**re: Response to City of Ottawa Comments**  
**Proposed Multi-Storey Building - 440 and 444 Bronson Avenue - Ottawa**  
**to: Fotenn - Mr. Jeff Nadeau - nadeau@fotenn.com**  
**to: TC United - Mr. Daniel Boulanger - dan.boulanger@tcunitedgroup.com**  
**date: May 2, 2019**  
**file: PG4304-MEMO.01**

T.C UNITED	
NOISE ATTENUATION STUDY	
440 BRONSON AVENUE	
OTTAWA,	ONTARIO
Title: SITE GEOMETRY - REC 1-1 , REC 1-6

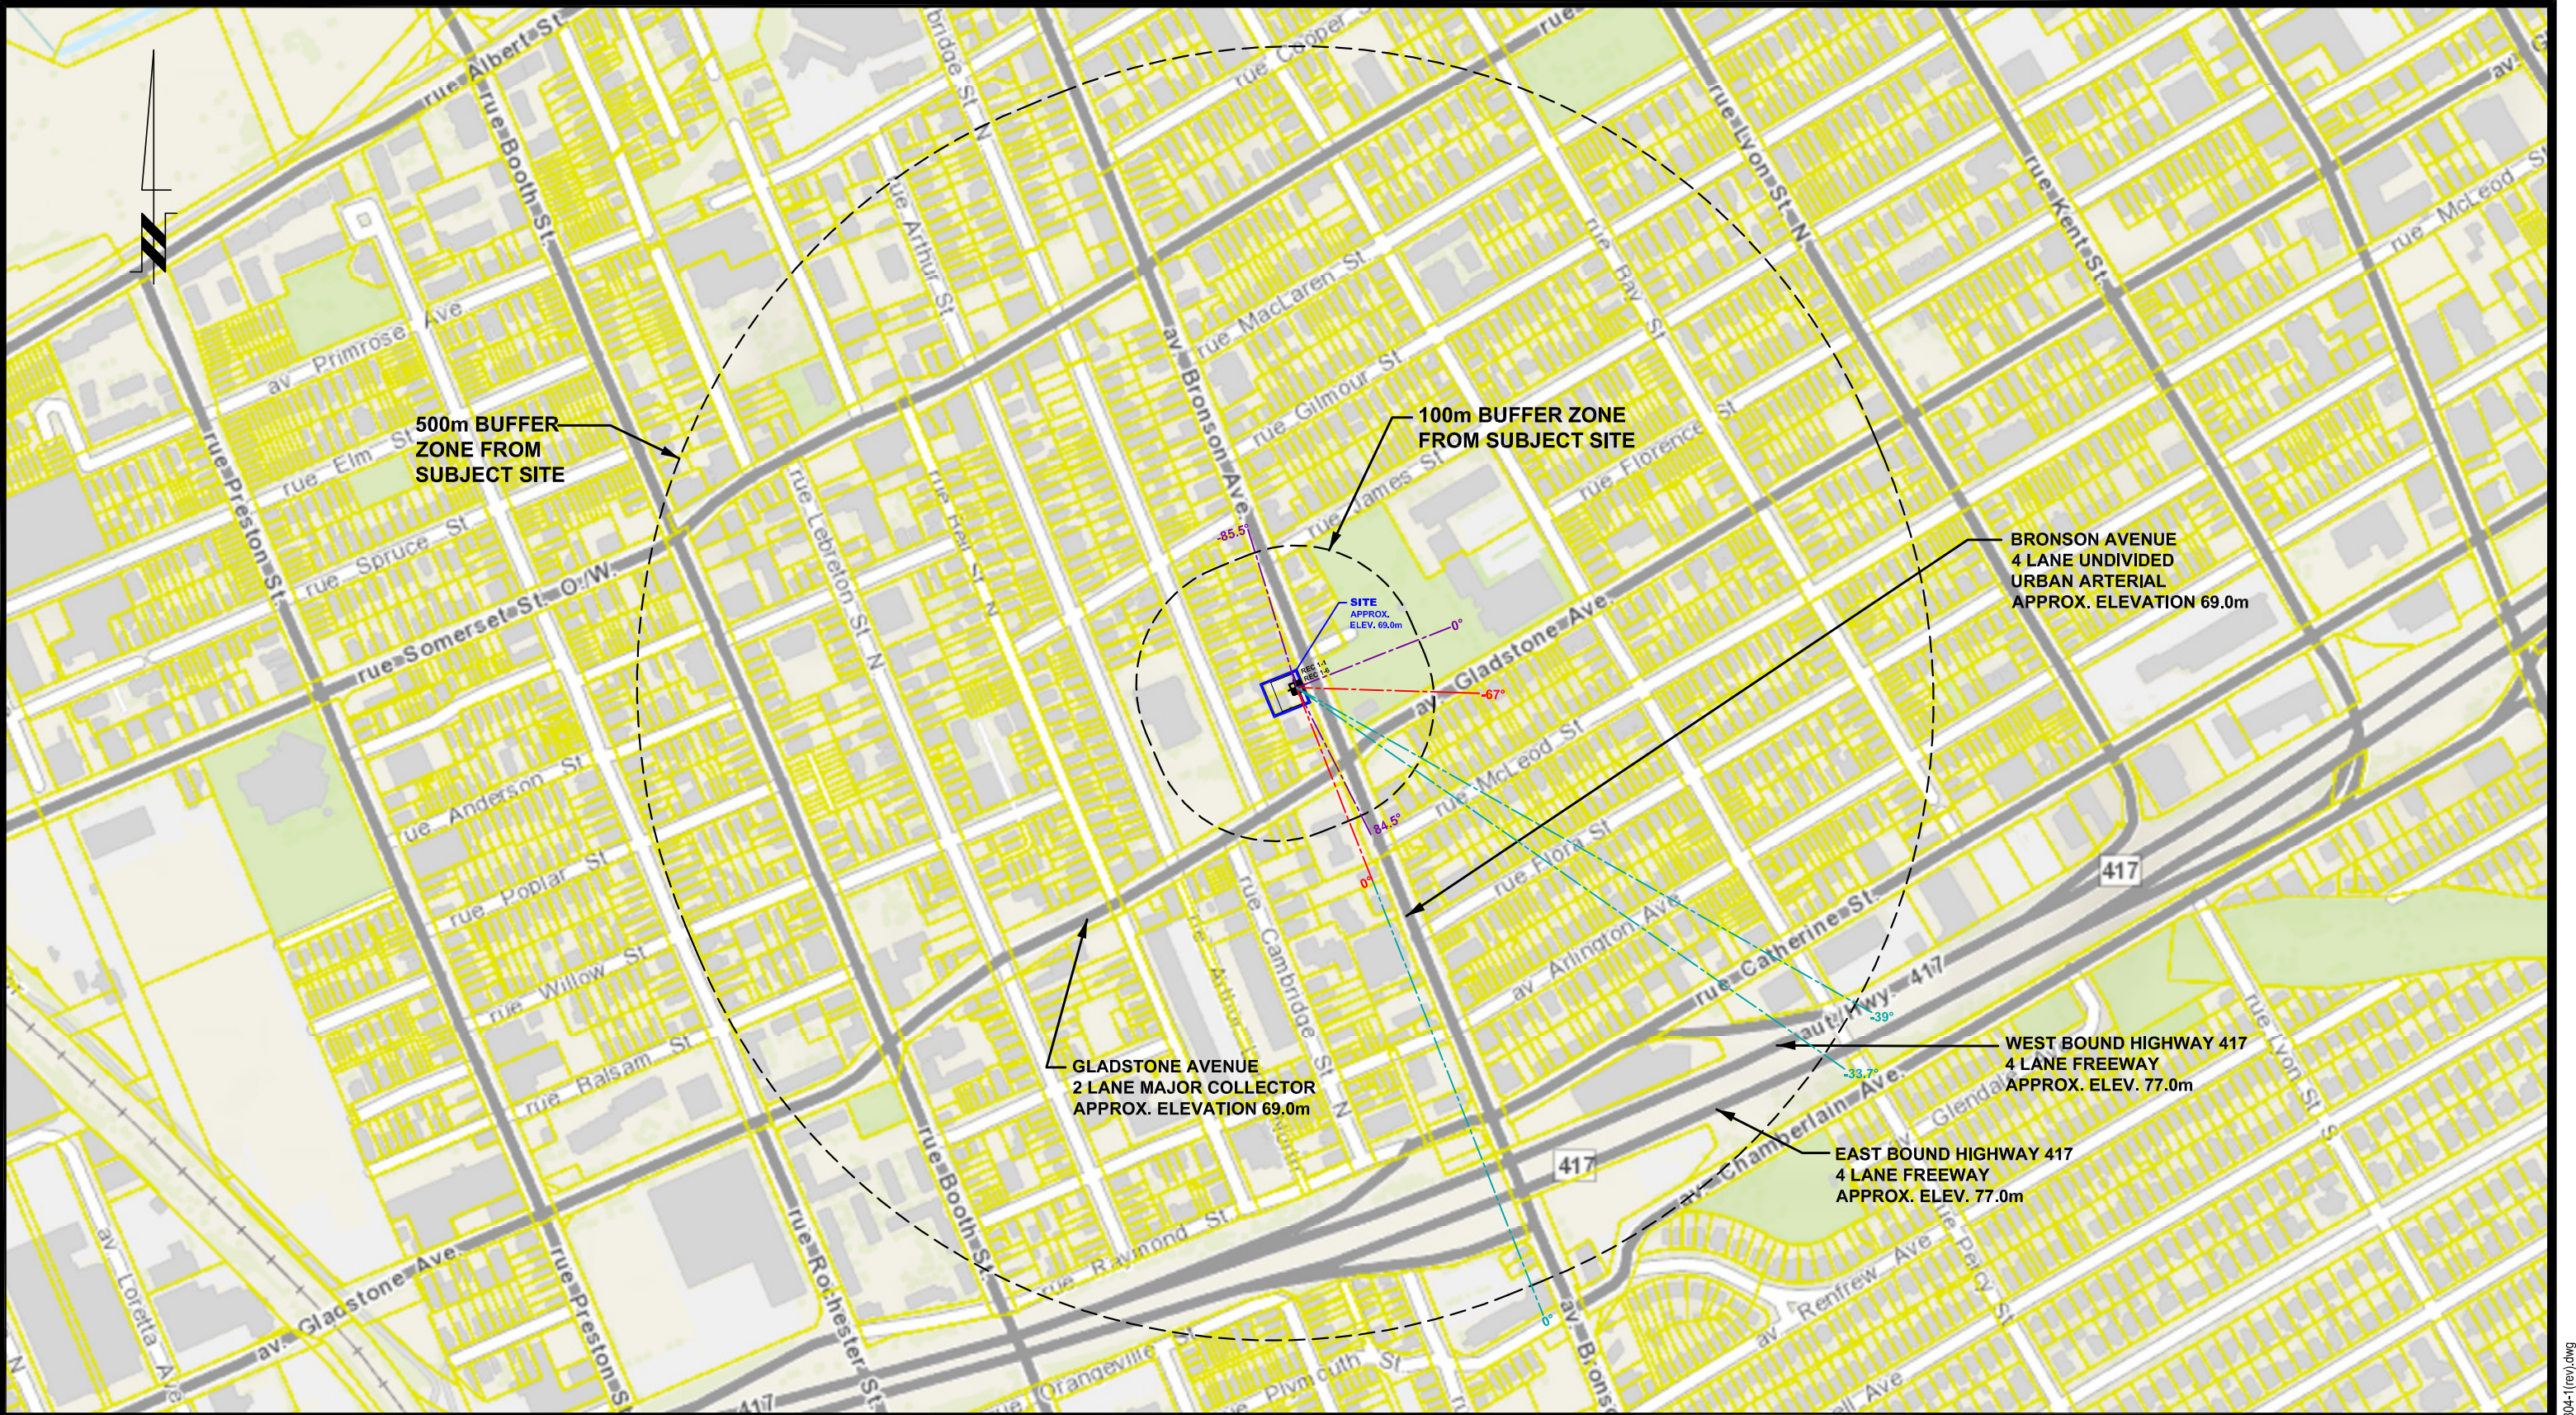
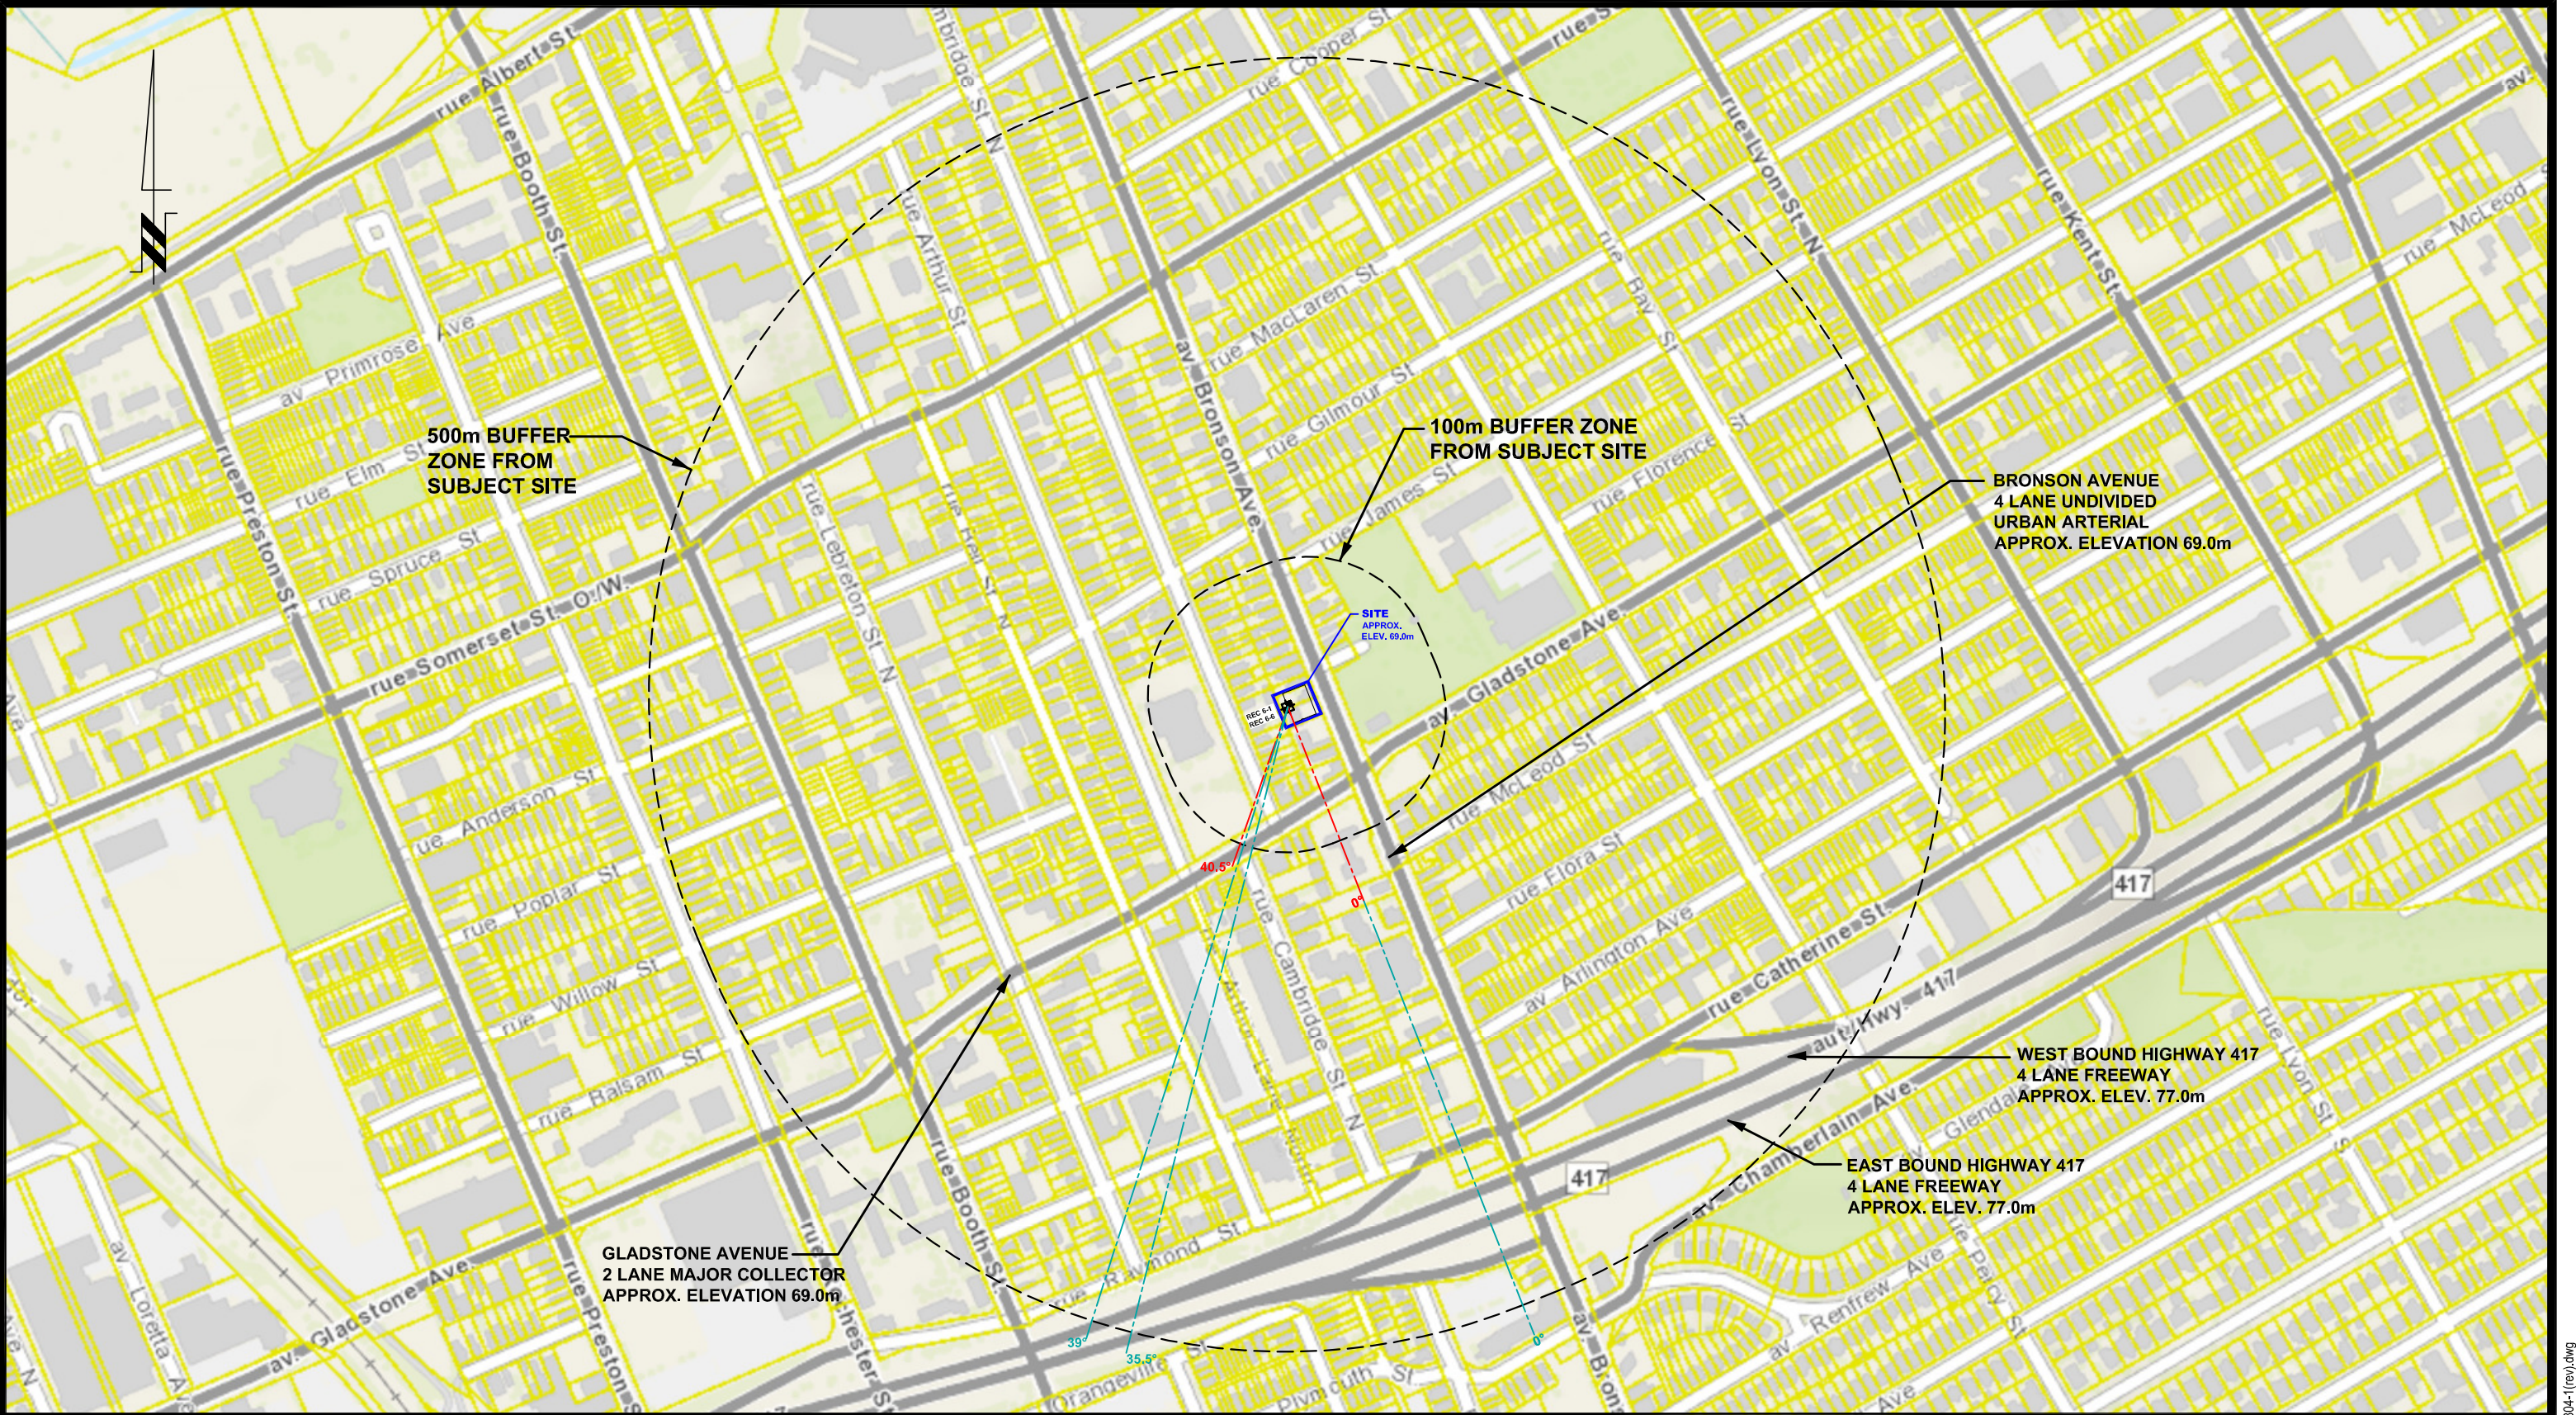
Provide scaled plan with distances and angles between noise sources and installed receptors as per Environmental Noise Control Guidelines – Section 3.1.1 c) – Revise

The aforementioned noise attenuation study has been updated with the scaled plans, located in Appendix 1.
